Application Ref:	3/2025/0671			 Ribble Valley Borough Council www.ribblevalley.gov.uk	
Date Inspected:	N/A	Site Notice:	N/A		
Officer:	LW				
DELEGATED ITEM FILE REPORT:				Decision	PERMISSION NOT REQUIRED

Development Description:	Prior notification for proposed agricultural storage building under Part 6 Class A of the GPDO 18.3m long, 12.2m wide, 4m high to eaves and 5.5m high to ridge.
Site Address/Location:	Buckley Hall Farm, Preston Road, Ribchester, PR3 3YD.

Title: Elevations

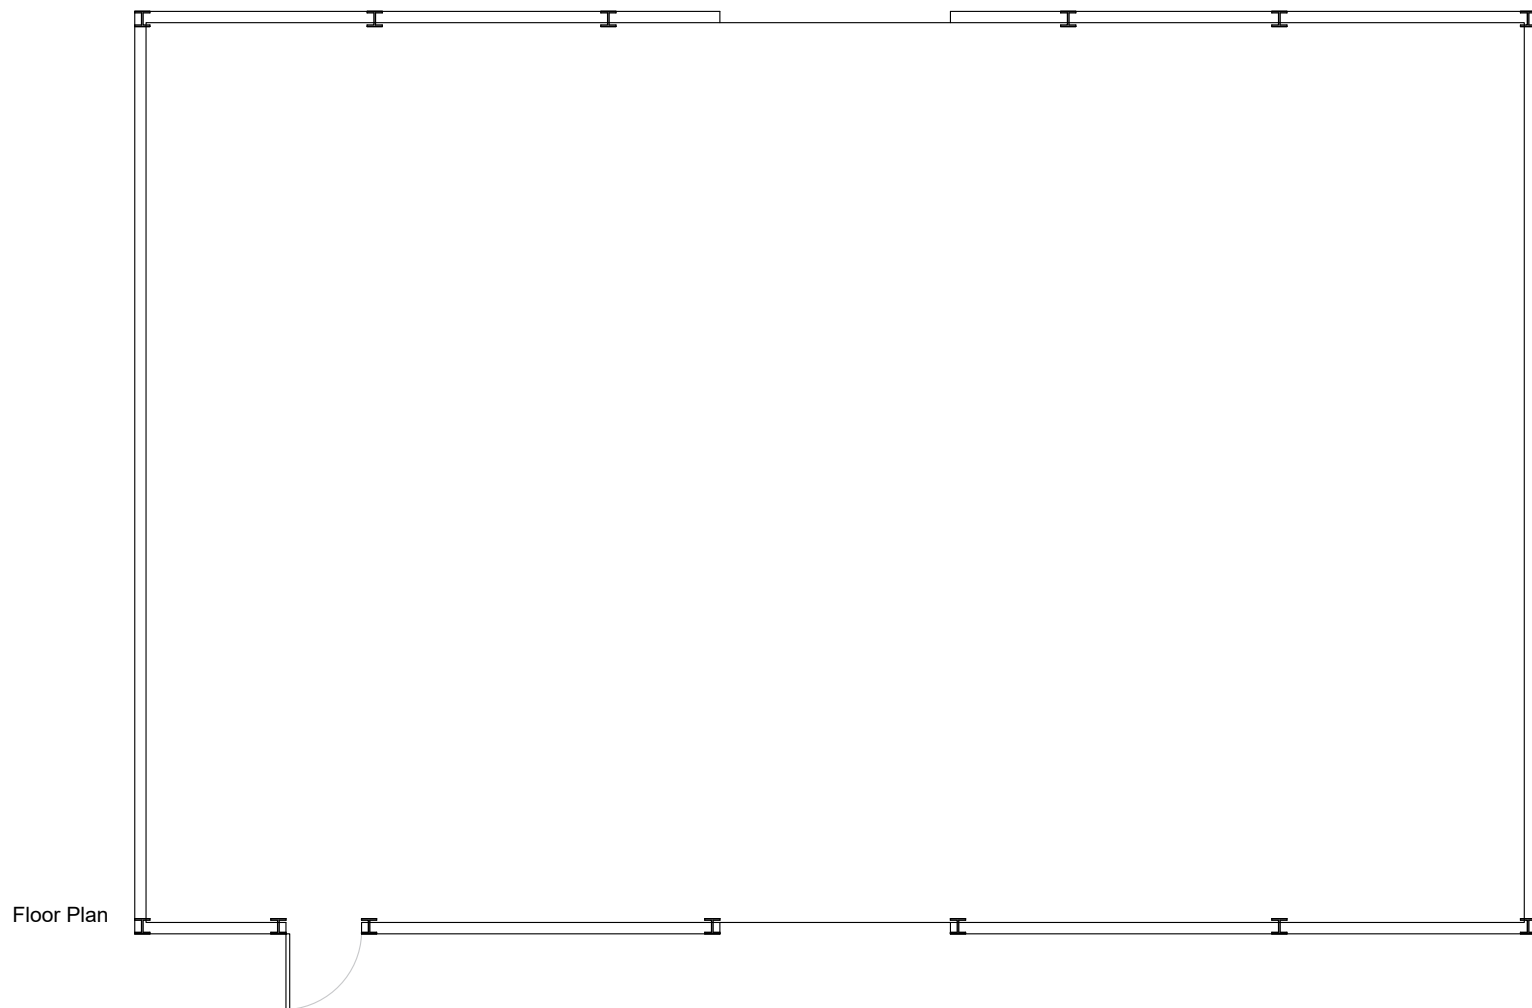
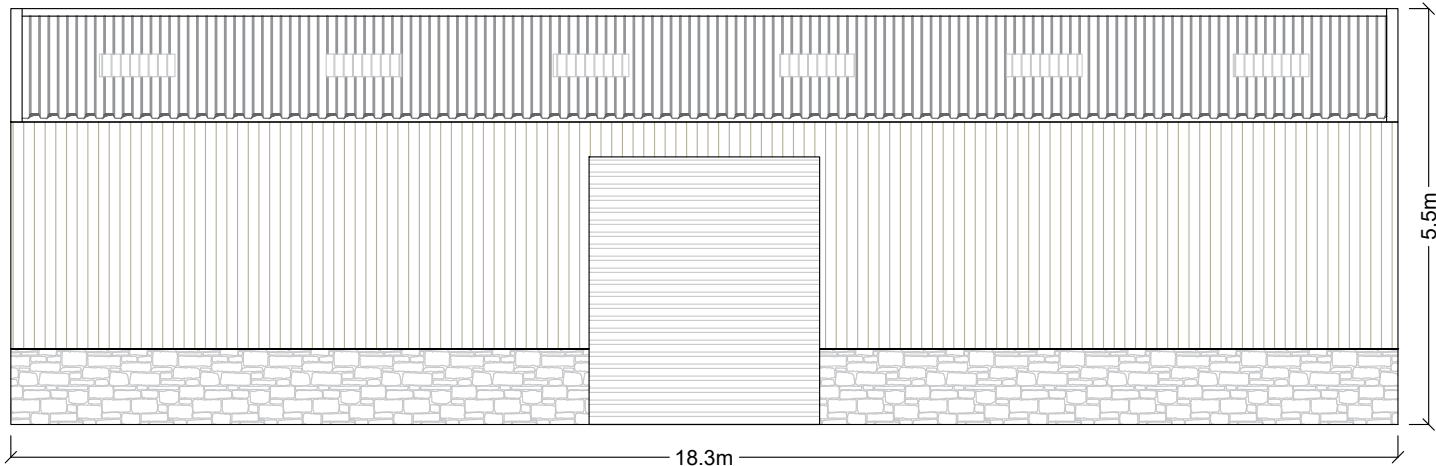
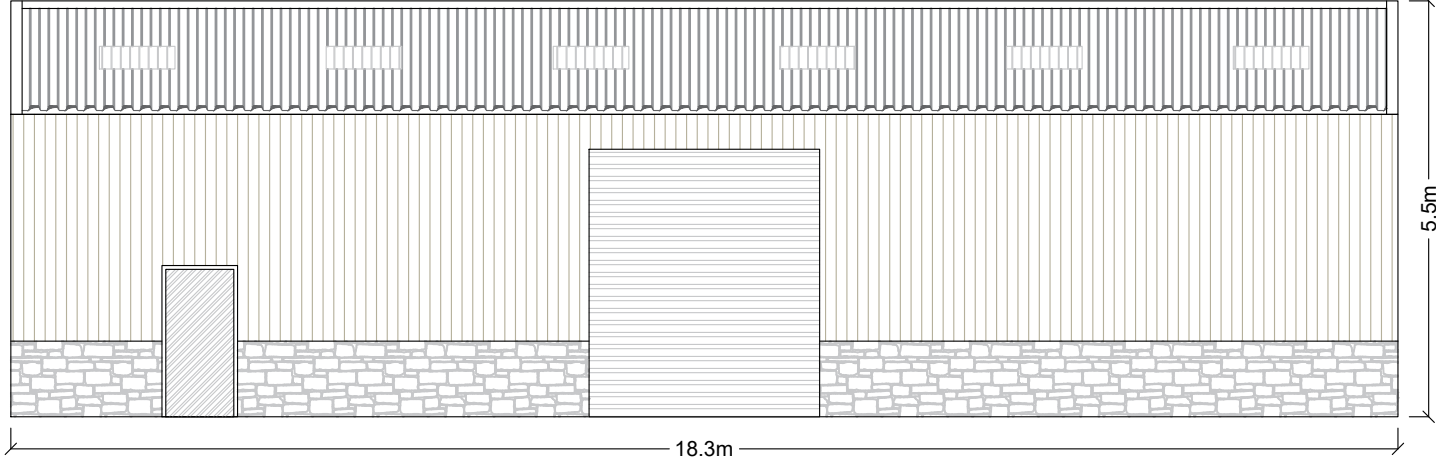
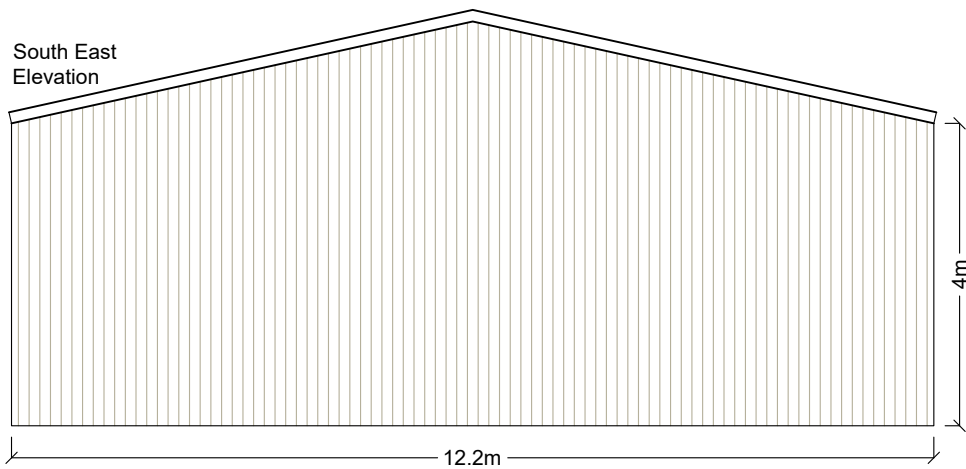
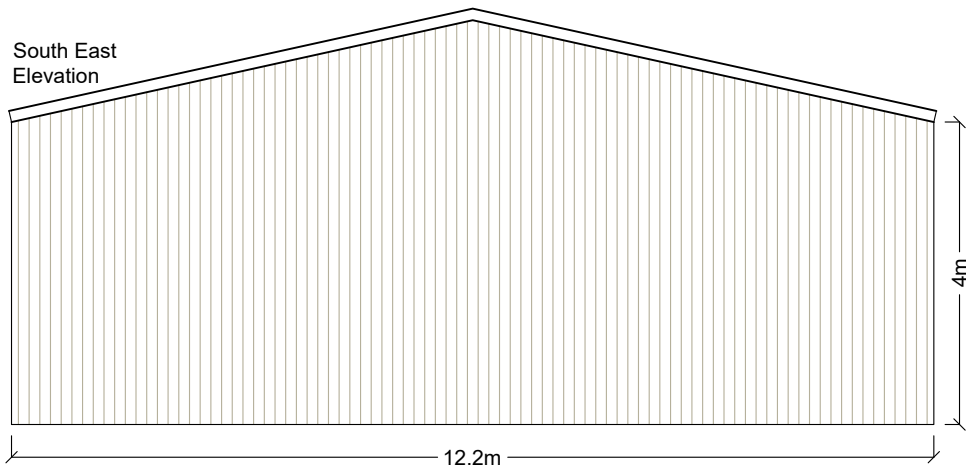
The proposed building would have stone to the lower elevations and Yorkshire boards to the remaining elevations with a roof of metal profiled sheeting. There would be a personnel door and galvanised steel roller shutter doors in the northern and southern elevations. With reference to application 3/2023/0498, the Inspector concluded that in isolation, the building's appearance is acceptable, with its form and materiality being clearly agricultural.

As such Prior approval is not required in terms of design and appearance.

Title: Site Plan

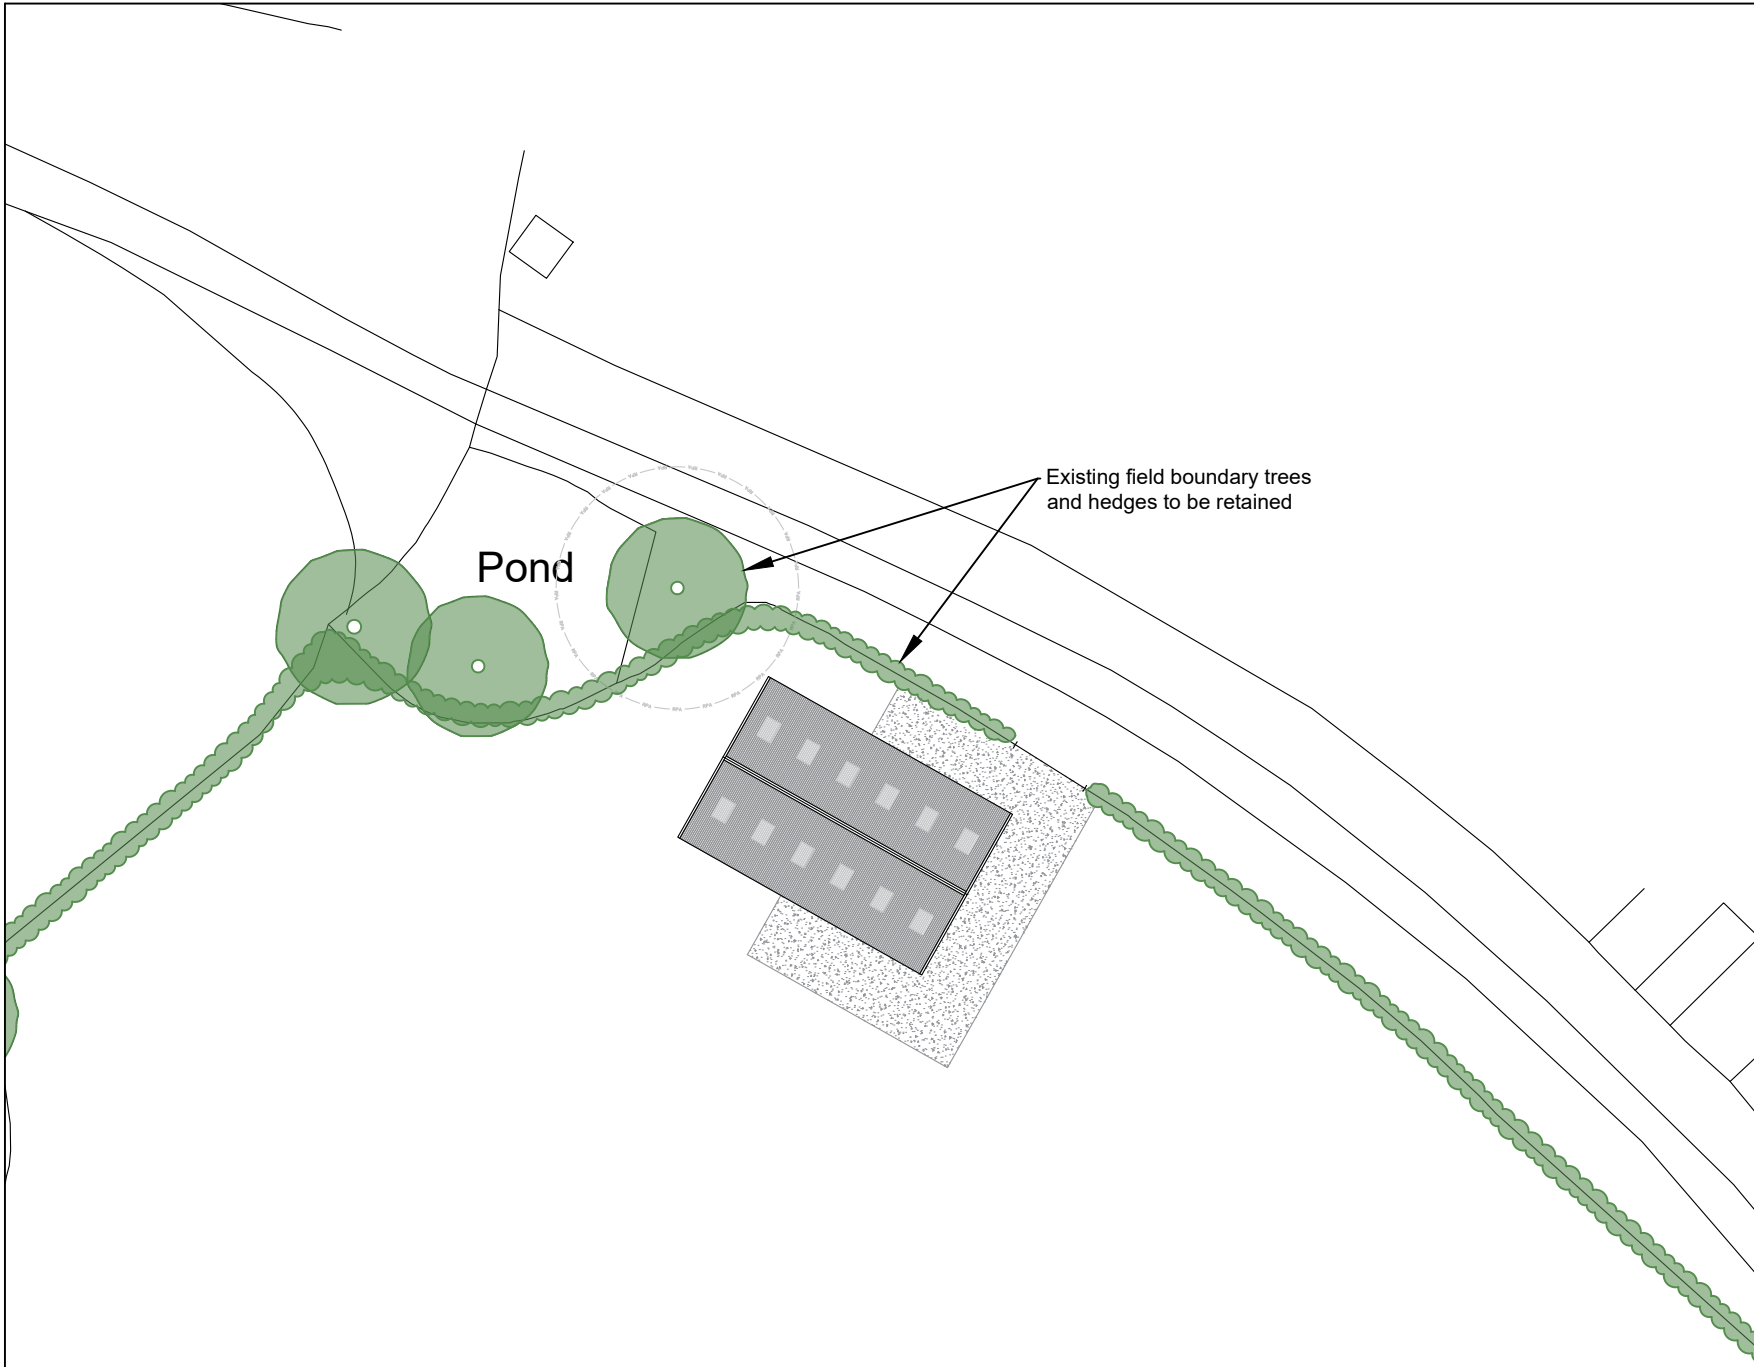
The closest buildings to the proposal site, approximately 100m to the south-east, are Buckley Hall Farmhouse and the Grade II Listed Old Buckley Hall. Whilst the clustering of new built form with existing buildings offers visual benefits in reducing impact on the openness of the surrounding countryside landscape, the siting of the building closer to the existing built form would result in the development unduly competing with the existing prominence and architectural interest of the aforementioned buildings, particularly given the size and massing of the proposed building and in the absence of any similar structures in the immediate locality. Whilst separated from the aforementioned built form, the proposed building would be sited directly adjacent to an existing field access, minimising the extent of new hard surfacing required for vehicles access and egress, with the existing boundary hedging also providing some degree of visual screening from users of the Public Right of Way which runs along the access track.

Alternative locations for the building have also been considered and discounted due to the extent of hardstanding which would be required were the building located further into the field, as well as the impact on existing utilities, proximity to Buckley Hall Farmhouse and Old Buckley Hall and increased visibility from the Public Right of Way. Taking account of the above constraints, the proposed location is considered the most suitable siting for the building.

It is noted that the development would be within close proximity to trees; however, it is not anticipated that any direct impact would be resultant, given the building would be located outside of the Root Protection Area as shown on the submitted Site Plan.

As such prior approval is not required in terms of siting.
